EMAIL TRANSMISSION

SUBJECT: Tomingley Gold Mine MOD2 – Response to submissions

The purpose of this email transmission is to provide the Department with a response to comments and submissions received in relation to the application by Tomingley Gold Operations Pty Ltd (the Applicant) to modify PA 09_0155 for the Tomingley Gold Mine. Given the limited number of submissions received and the generally minor nature of the issues raised, this response has been prepared as a brief letter report.

Figure 6  
MODIFIED FINAL LANDFORM  
AND LAND USE

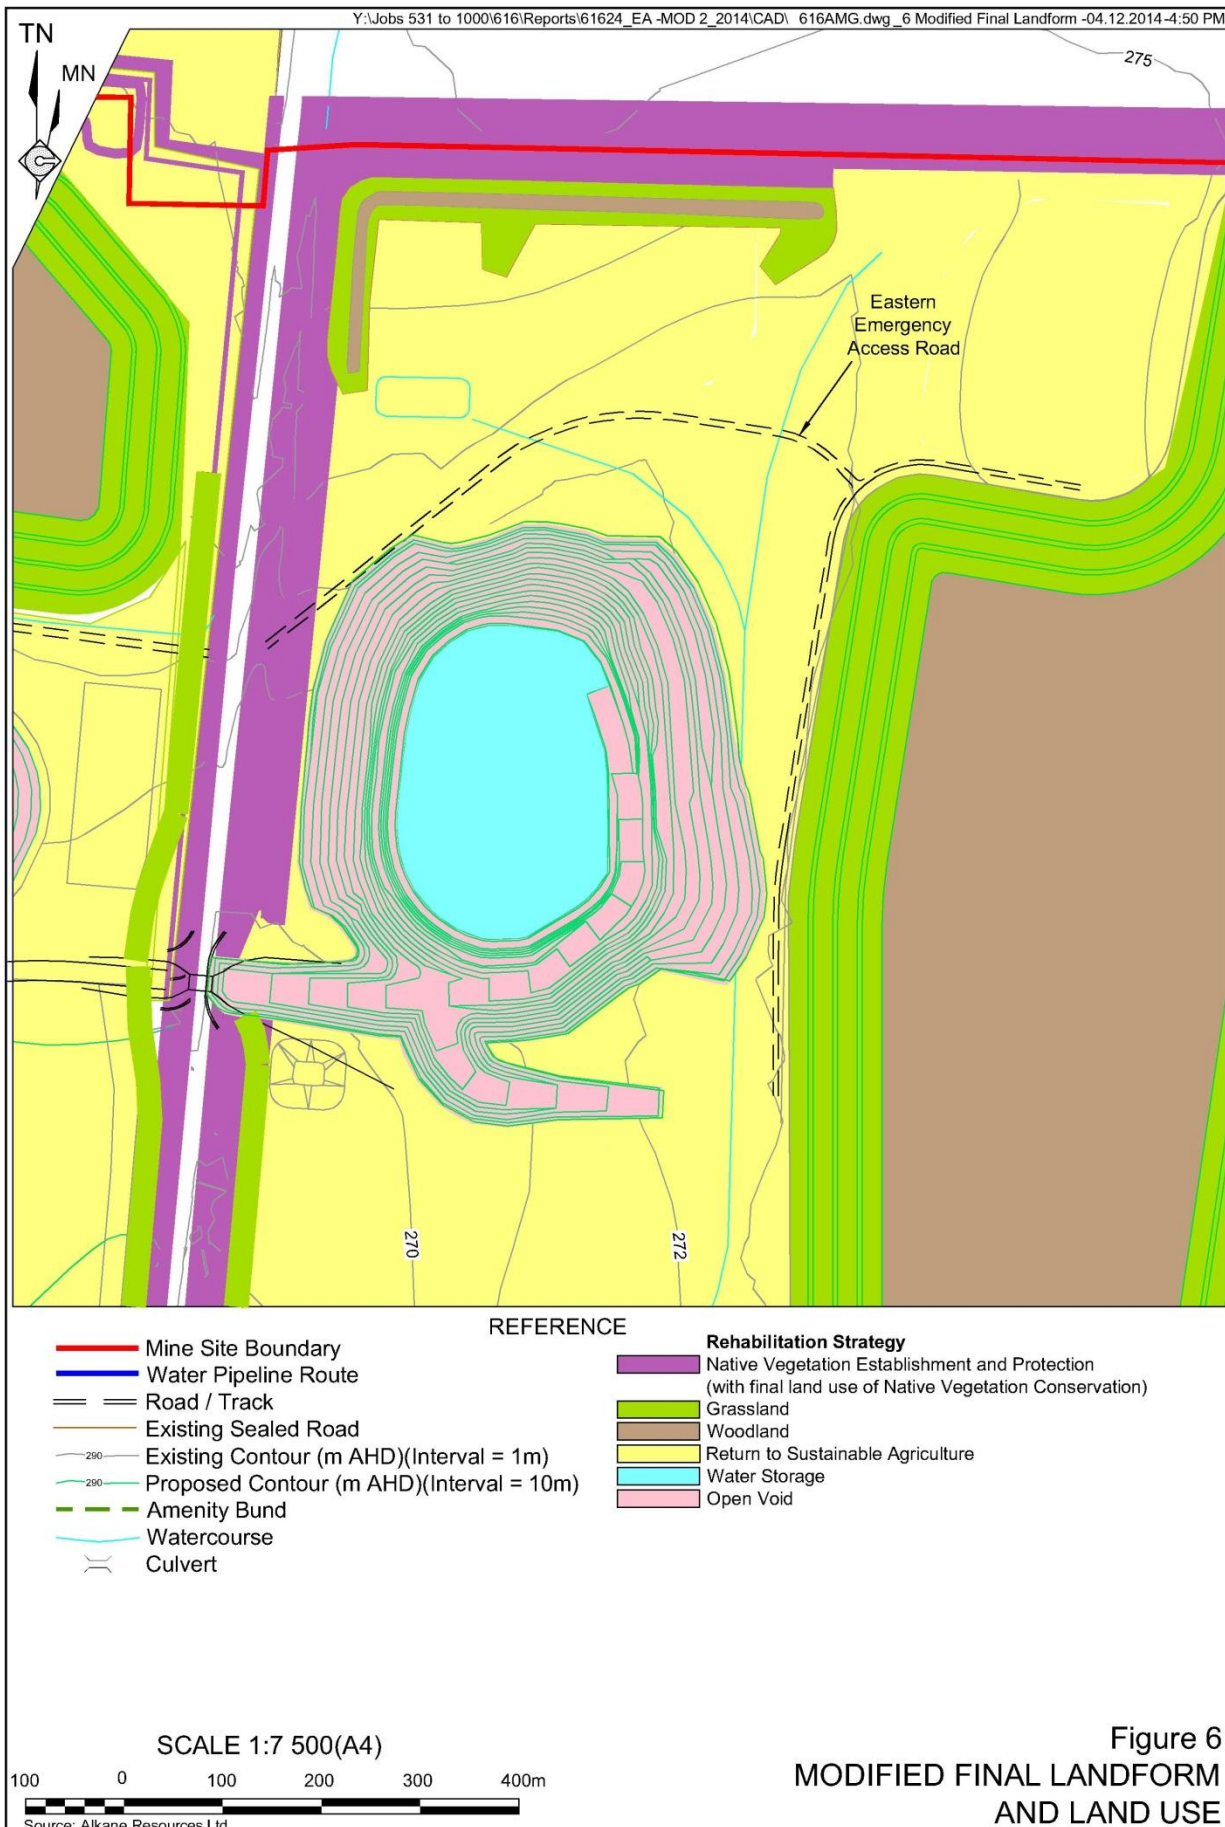
- *Provide an updated Biodiversity Offset Strategy figure (Appendix 5 in the current Project Approval) that shows the proposed modified mine layout (Figure 9 in the EA is not equivalent); and*
- *Provide an updated rehabilitation plan (Appendix 6 in the current Project Approval) covering the whole site that incorporates the modified landform as per Figure 6 of the EA.*

The requested figures are attached to this email. It is noted that the *Biodiversity Offset Strategy* figure is to be replaced with the plan recently endorsed by Local Land Services. The final landform figure has been adjusted to be consistent with the approved Biodiversity Offset Plan.
